Your ref 3/2025/0652
Our ref DC/25/2452v4
Date 19-JAN-26

Location: Hall Barns Farm Knowles Brow Hurst Green BB7 9PT
Proposal: Proposed extension to existing approved agricultural building

Drawing Title
 PROPOSED SKETCH PLANS
 (GROUND FLOOR)

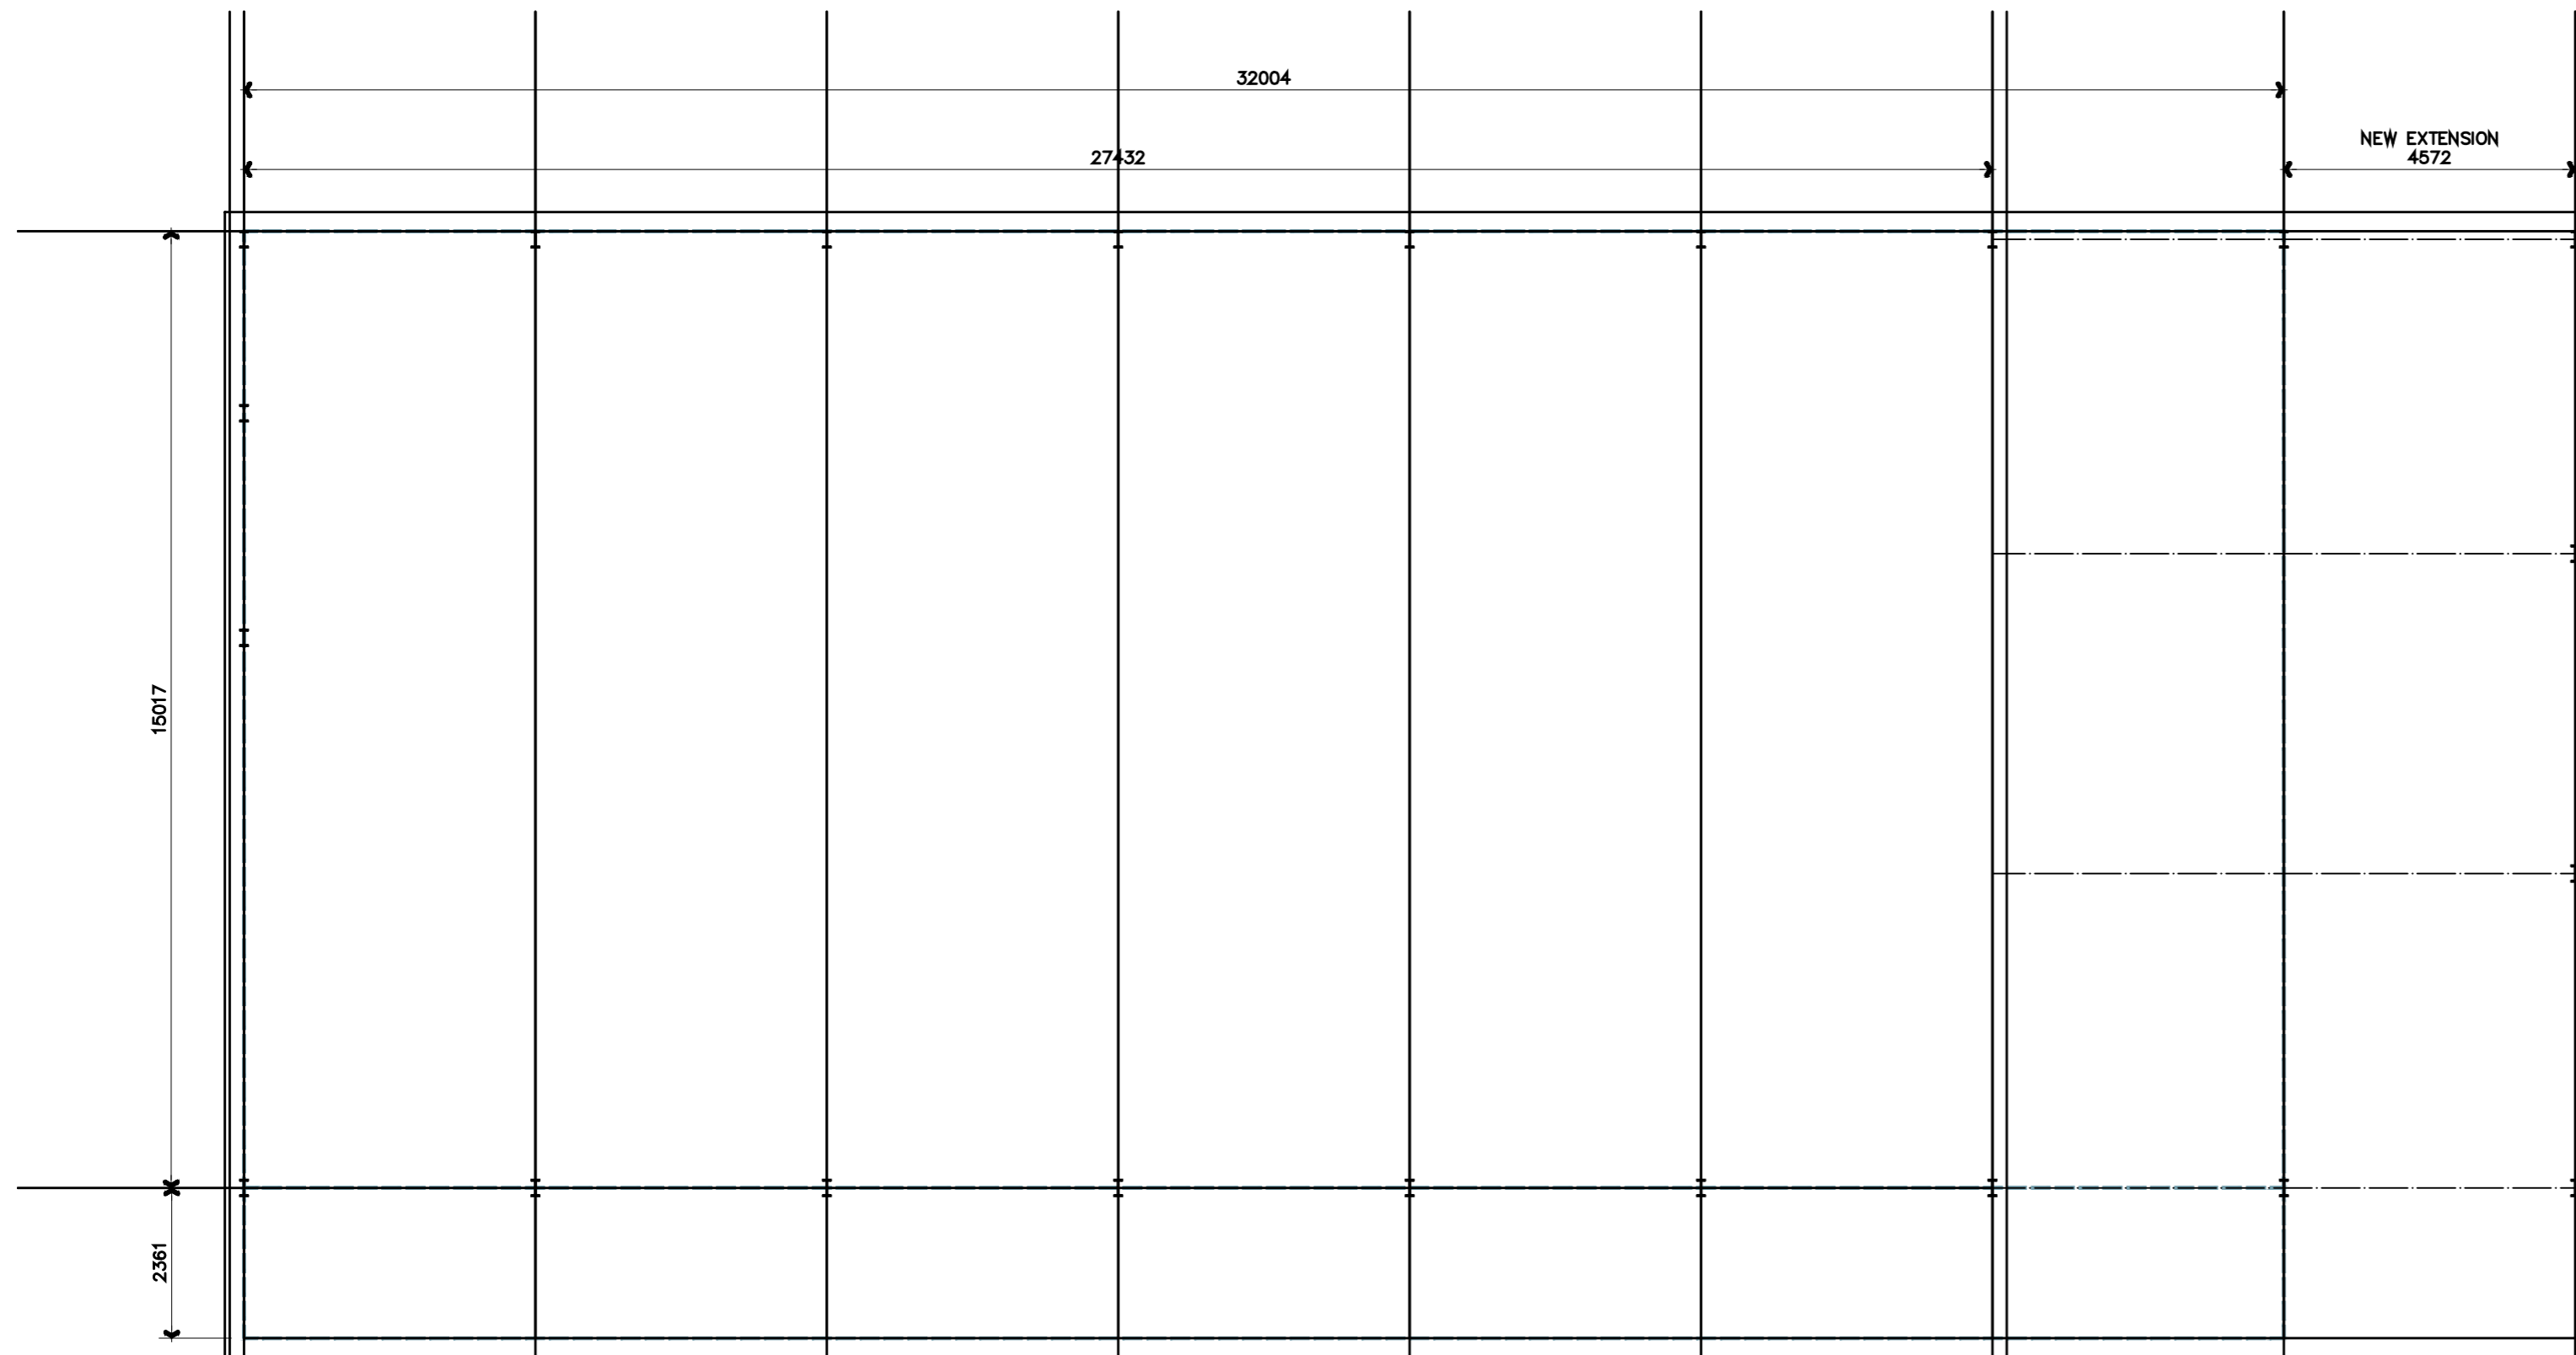
On review of the latest amended plan (Ref: 25 0652 AMENDED 20112025 Proposed site plan 1 250) United Utilities is satisfied that the proposed extension has been reduced to an acceptable size to avoid the existing infrastructure. The applicant should be made aware of the information, as set out below in '*United Utilities' Property, Assets and Infrastructure*'.

Following our review of the proposed site layout, it appears that our required access to the water main is provided. This is based solely on the information contained within DRAWING No. 0775/93/06B, as revised 15/11/2025). The acceptability of any proposal is dependent upon the applicant knowing the exact location (line and depth) of the asset in question, confirmed through their site specific investigations. The precise location of United Utilities assets is critical as this could be material to the detail of the final site design; including any proposed crossings of the asset with either above or below ground features (including utility services).
